DOC17/599447-01
SSD 8647

SSD 8647 – HORNSBY HOSPITAL RE-DEVELOPMENT – ENVIRONMENTAL IMPACT STATEMENT (EIS)

HORNSBY HOSPITAL RE-DEVELOPMENT STAGE 2 EIS

Noise Monitor Along Burdett Street: Tuesday 06 June, 2017

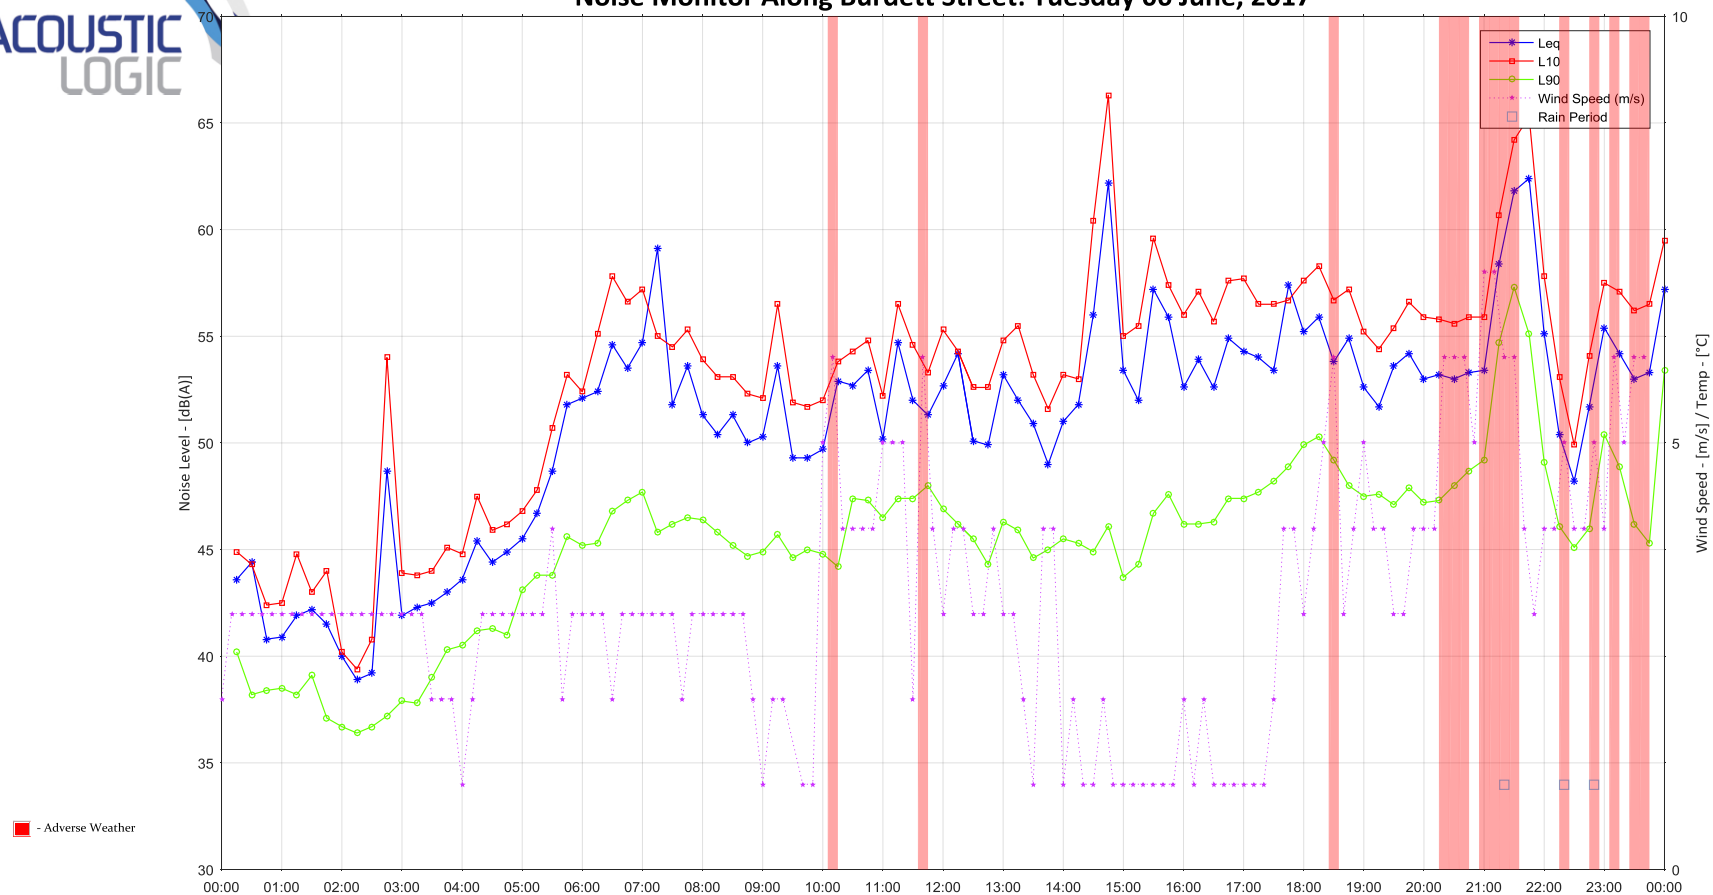
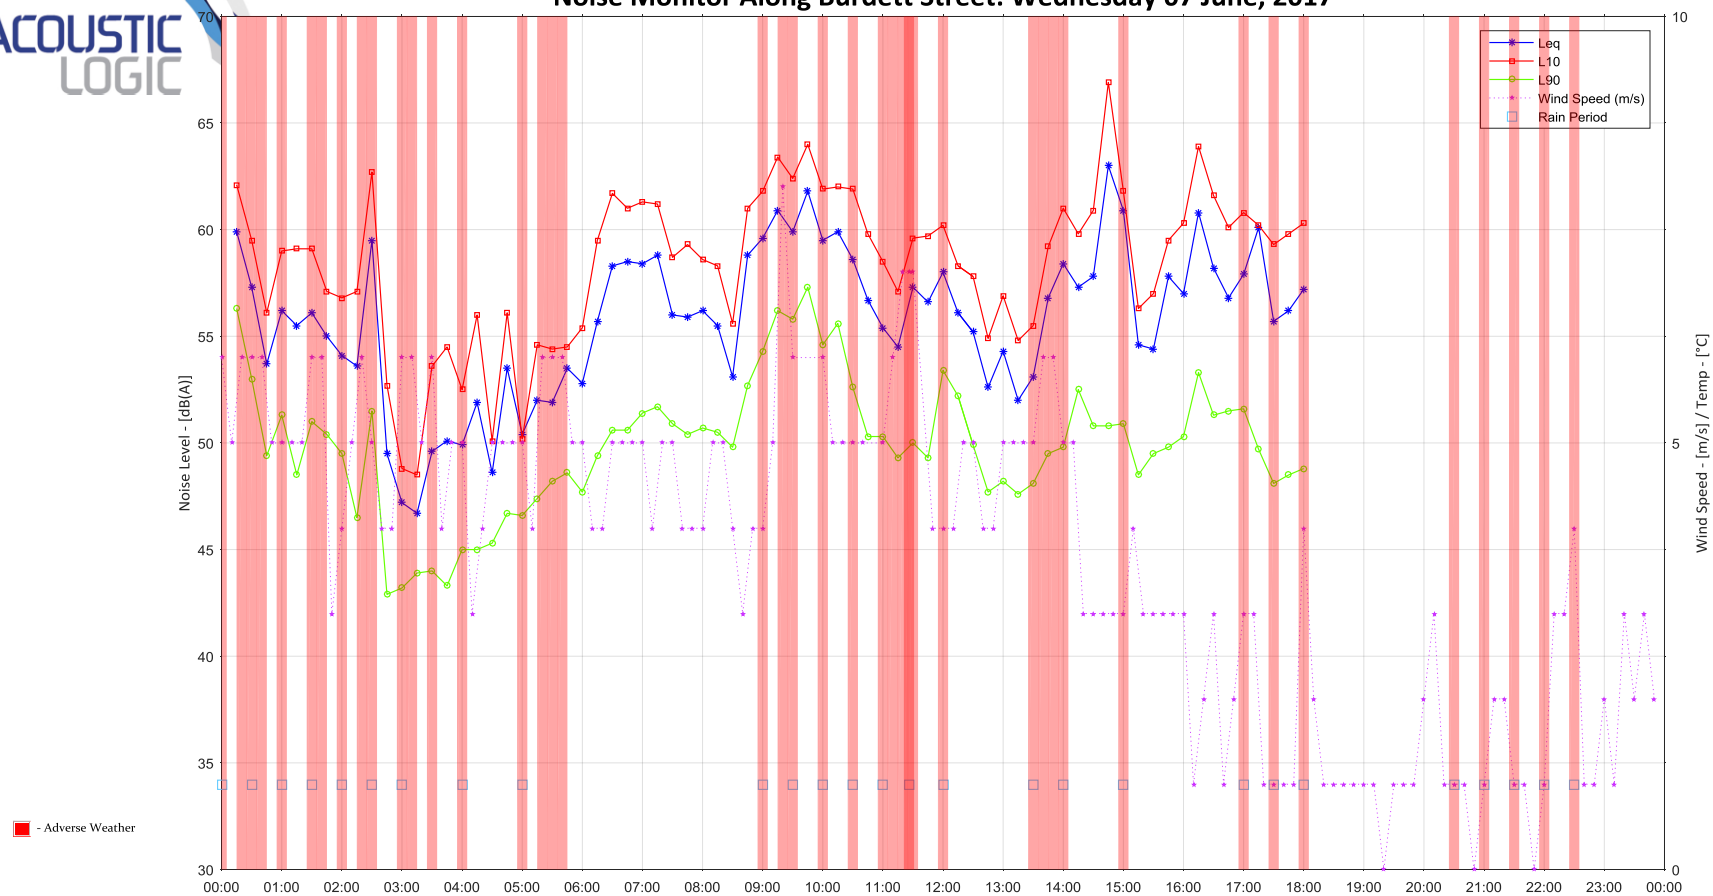
Section 4.1 to Appendix Q states that "[o]n review of the monitoring data, the measured L_{90} noise levels during high wind speed days generally do not increase background noise level significantly". The EPA considers the foregoing statement to be inaccurate for the graphs presented of the Burnett Street data, which show exactly the opposite for the evening of 6 June and all the data for 7 June.

- (a) the legends to some monitoring graphs appear to be misaligned (e.g. wind speed, rain period),

- (b) the legends to monitoring graphs includes a blue marker for 'rain period' and although rain was observed on several days during the various monitoring periods (i.e. 24 May to 7 June 2017), no rain periods are represented in the graphs, and
- (c) some of the monitoring graphs include sections of red highlight, but there is no red marker in the legend to those graphs to identify the meaning of those red highlighted periods, and
- (d) Appendix Q does not appear to identify when noise monitoring loggers were last laboratory calibrated which brings into question reliability of the recorded data.

- (a) the equivalent of a week's worth of valid data, measured at the potentially most affected noise sensitive receiver locations in Burdett Street, Derby Street and Palmertson Road; and
- (b) the results of attended monitoring, graphical results of unattended monitoring with a complete and accurate legend together with a table of assessment background and daily ambient levels.
